# Gatwick Airport Northern Runway Project

The Applicant's Response to the Examining Authority's  
Written Questions – Resource and Waste Management

Application Document Ref: 10.16

PINS Reference Number: TR020005

Figure 5.1: Waste Sites within 15km in 2019

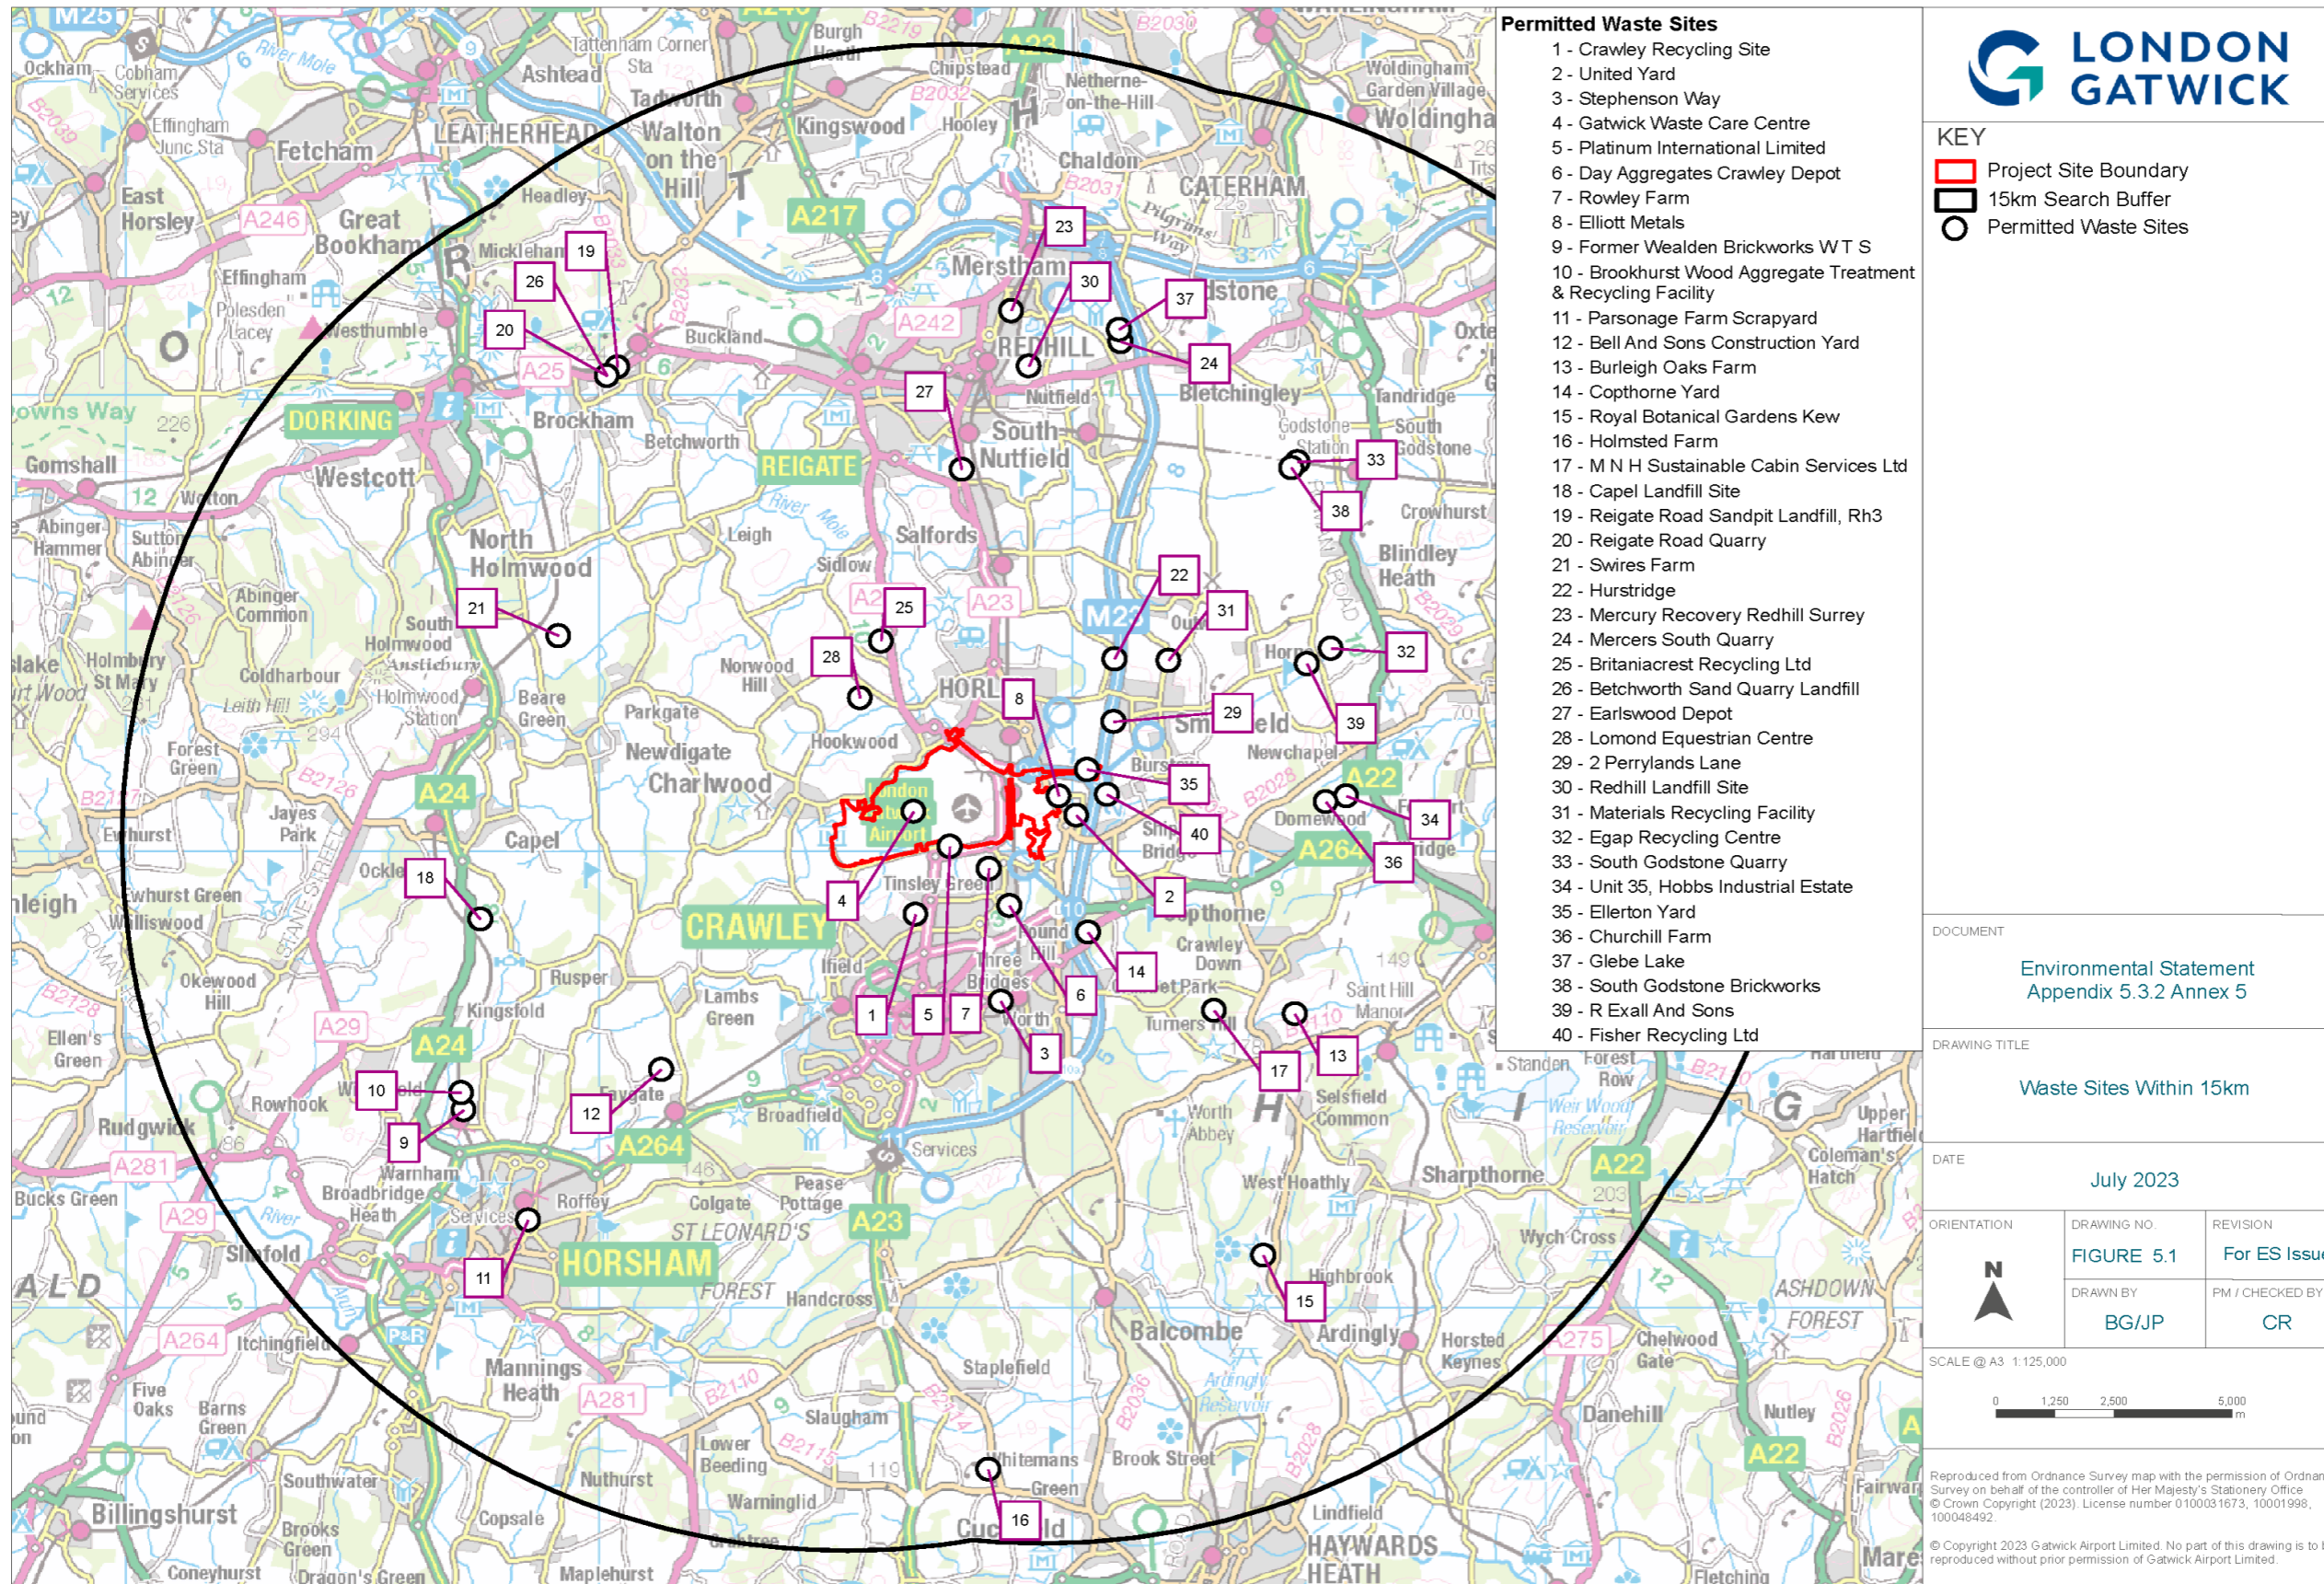
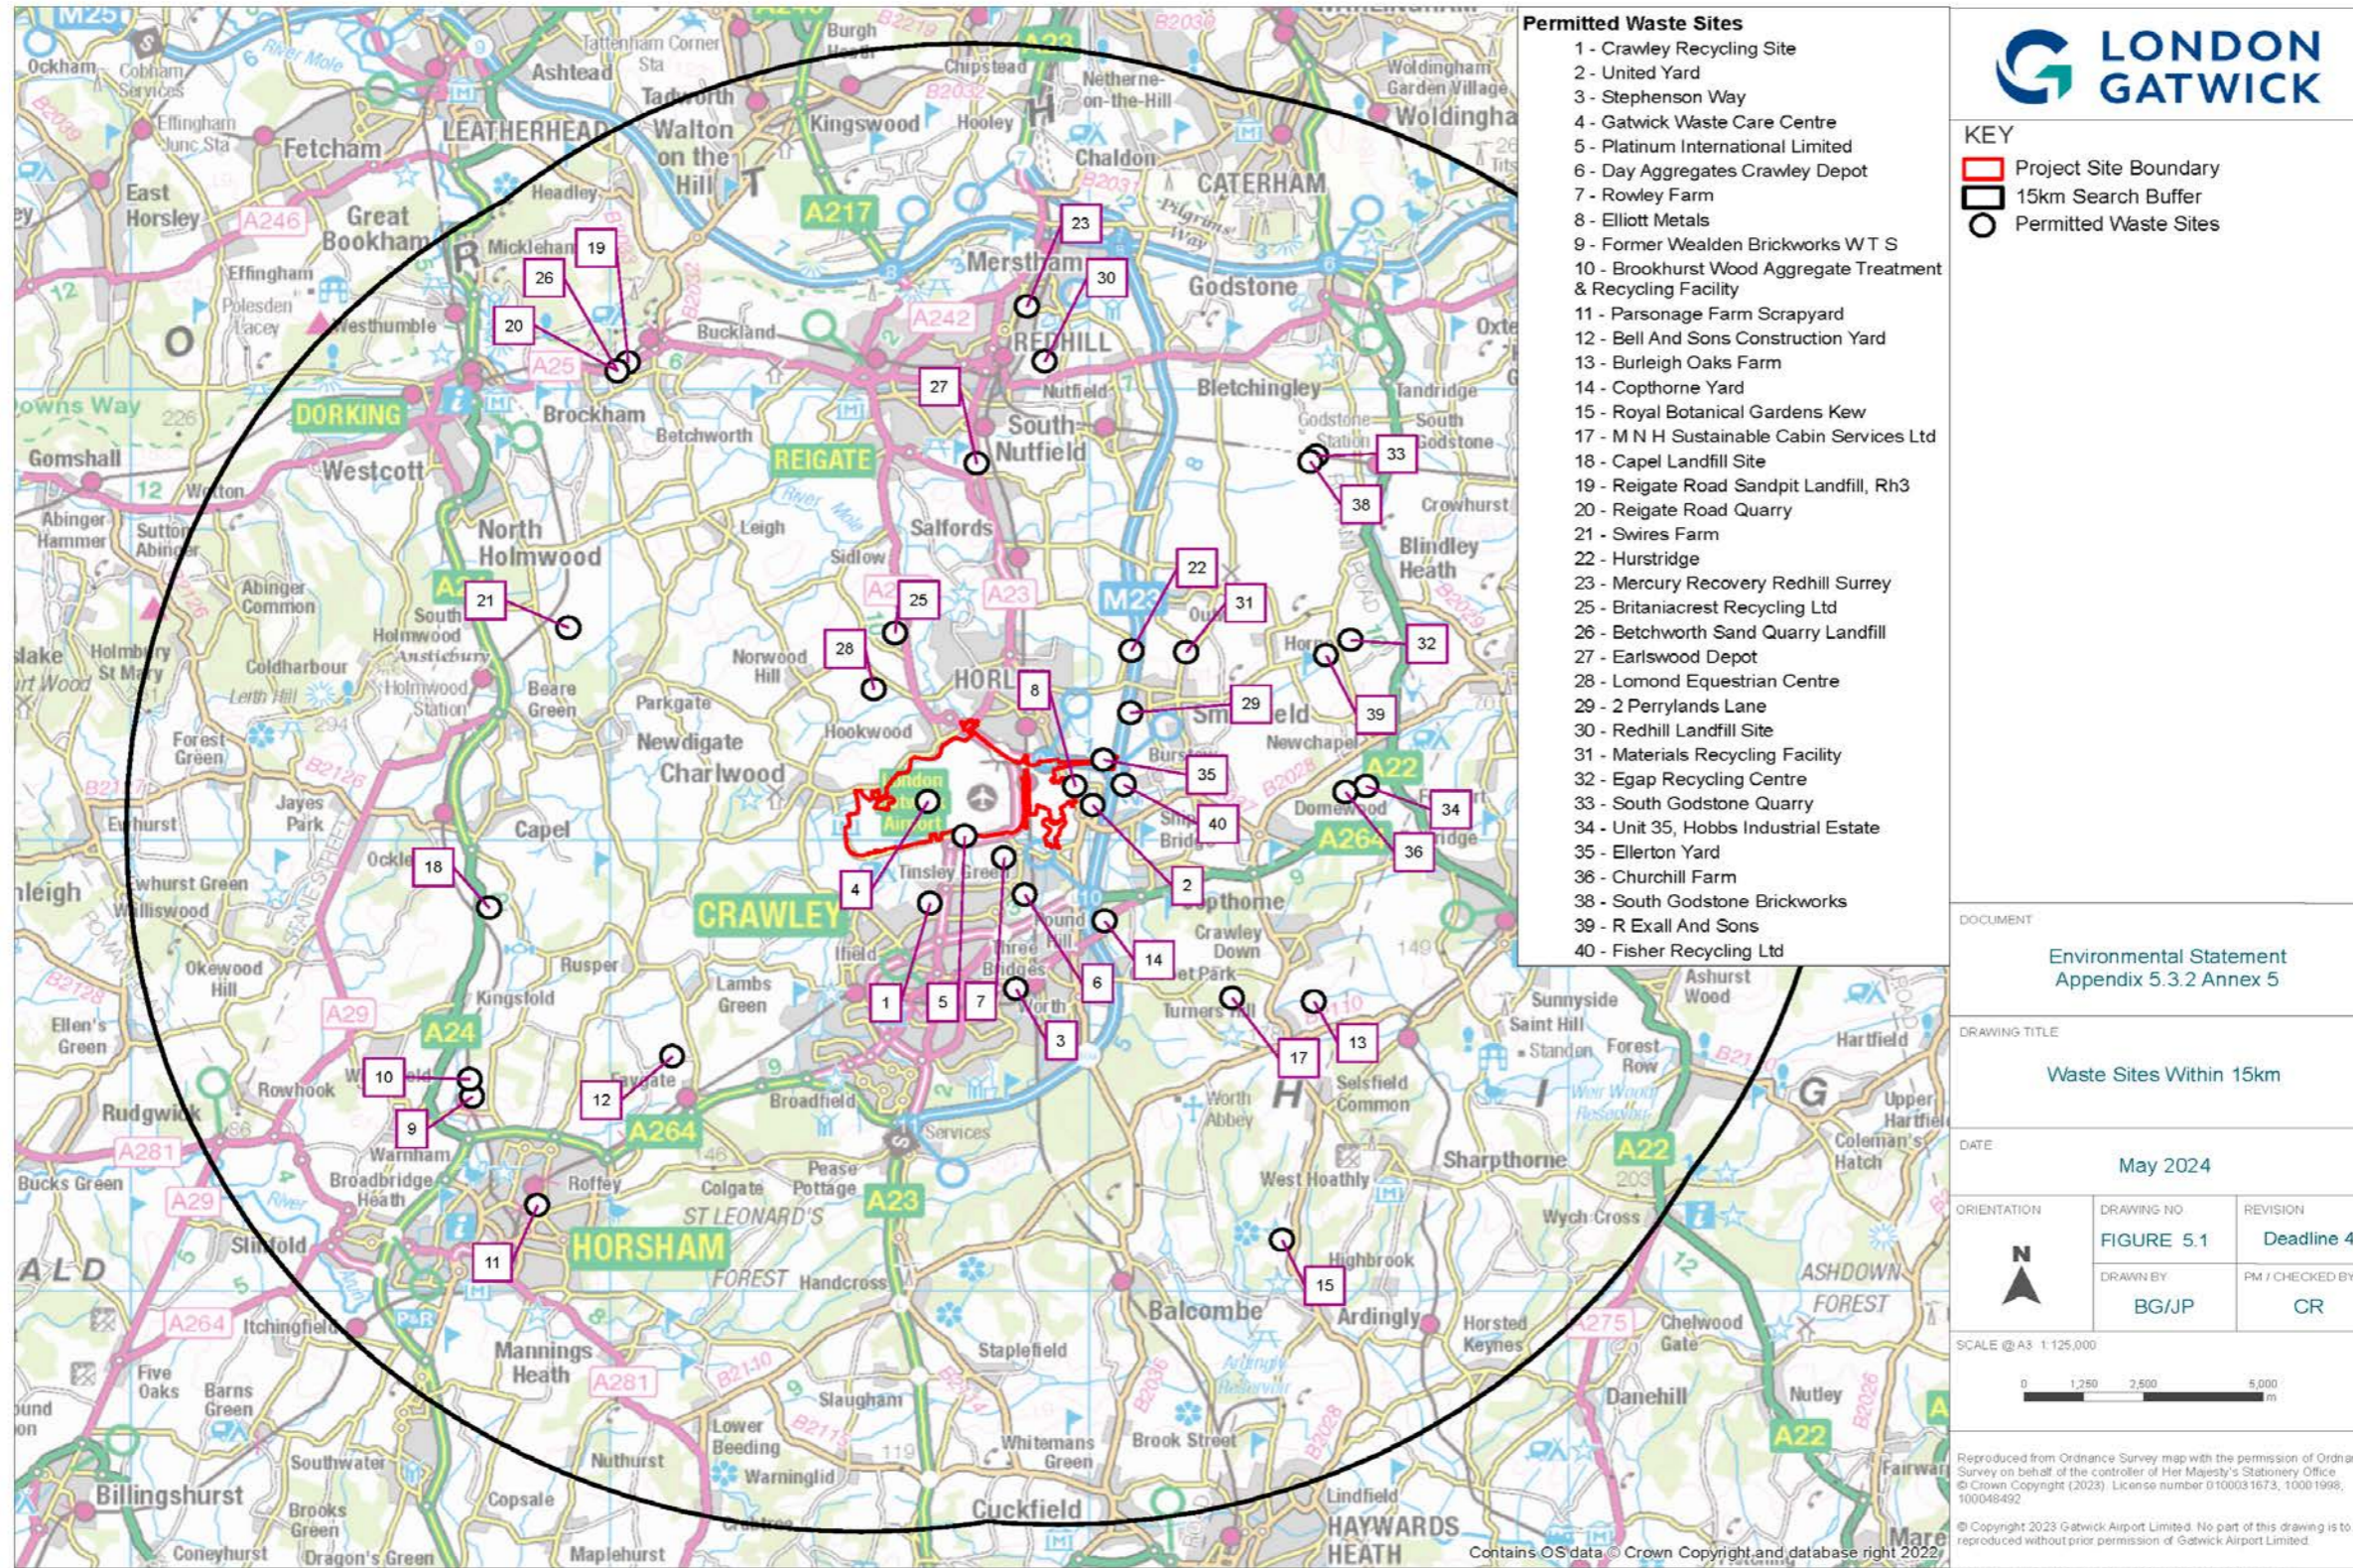
have been assessed in <b>ES Chapter 12: Traffic and Transport</b> [ <a href="#">AS-076</a> ].
RES.1.3	The Applicant	<p><b>Capacity for Waste Arisings</b></p> <p>Paragraph 5.2.14 of the Construction Resources Waste Management Plan [APP-087] states that waste forecasts have not been defined for the construction and operation of the Proposed Development.</p> <p>How can the ExA be satisfied that there is sufficient capacity for the different categories of waste arising from the Proposed Development?</p> <p>The existing waste management infrastructure presented in the <b>Construction Resources and Waste Management Plan</b> [<a href="#">APP-087</a>] is based on published information from West Sussex County Council, Surrey County Council and Environment Agency records at time of preparing the DCO Application. It does not include ongoing work undertaken by the RPAs to identify and secure new waste management sites or the agreements in place with neighbouring authorities on the movements of waste.</p> <p>The quantities and types of waste arising from the construction of the Project are not currently defined, therefore a comparison of waste forecasts from the Project cannot be made with the capacity of the waste management infrastructure which is also subject to change.</p> <p>The types and quantities of construction waste will be confirmed during detailed design. In accordance with the waste hierarchy principles (as set out in the <b>Construction Resources</b></p>

<p><b>and Waste Management Plan</b> <a href="#">[APP-087]</a> the Project will be required to minimise waste and divert waste from landfill where possible. The management of construction wastes will be set out in the Site Waste Management Plans that will take into account the waste management infrastructure in place at the time of the construction.</p> <p>Waste forecasts from the operation of the Project will be presented in the <b>Operational Waste Management Strategy</b> (Doc Ref. 10.12) submitted at Deadline 3. The management of operational wastes will be set out in the Operational Waste Management Plan that will take into account the waste management infrastructure at the time of completion - this is secured by DCO Requirement 25.</p>
RES.1.4	The Applicant	<p><b>Forecasted Waste Arisings</b></p> <p>Paragraph 5.2.6 of the Construction Resources Waste Management Plan (CoCP Annex 5 [APP-087]) refers to waste arisings to 2031 in the West Sussex Waste Local Plan (WSCC and SDNPA, 2019).</p> <p>Do these include waste arisings from the Proposed Development?</p> <p>The waste forecasts in the Waste Local Plan (adopted 2014) are calculated using a base case and applying growth rates using different growth scenarios rather than the inclusion of waste estimates from individual projects. The growth rates are reviewed on an annual basis. The Review of the Waste Local Plan (2019) considered the methodology used to forecast waste arisings (in particular, construction, demolition and excavation waste (CD&amp;E)) and the waste forecasts were updated. The waste forecasts referred to in the <b>Construction</b></p>

<p><b>Resources and Waste Management Plan</b> <a href="#">[APP-087]</a> refer to the high growth scenarios from the Review of the Waste Local Plan (2019).</p>
RES.1.5	The Applicant	<p><b>Outline Dust Management Plan</b></p> <p>In the Joint West Sussex LIR [REP1-068], the local authorities note that no dust management plan has been provided by the Applicant.</p> <p>The Applicant is asked if an outline dust management plan will be submitted into the Examination and if not, why not.</p>
		<p>An outline Dust Management Plan has been shared with the local authorities for review at Deadline 2.</p>
RES.1.6	The Applicant	<p><b>Outline Operational Waste Management Plan</b></p> <p>In the Joint West Sussex LIR [REP1-068], the local authorities state that an outline operational waste management plan should be provided. This is secured by DCO Requirement 25.</p> <p>The Applicant is asked if an outline operational waste management plan will be submitted into the Examination. If an outline plan is not intended to be submitted, the Applicant is asked to explain how the ExA can be satisfied that the waste produced will be properly managed, in line with the waste hierarchy.</p>
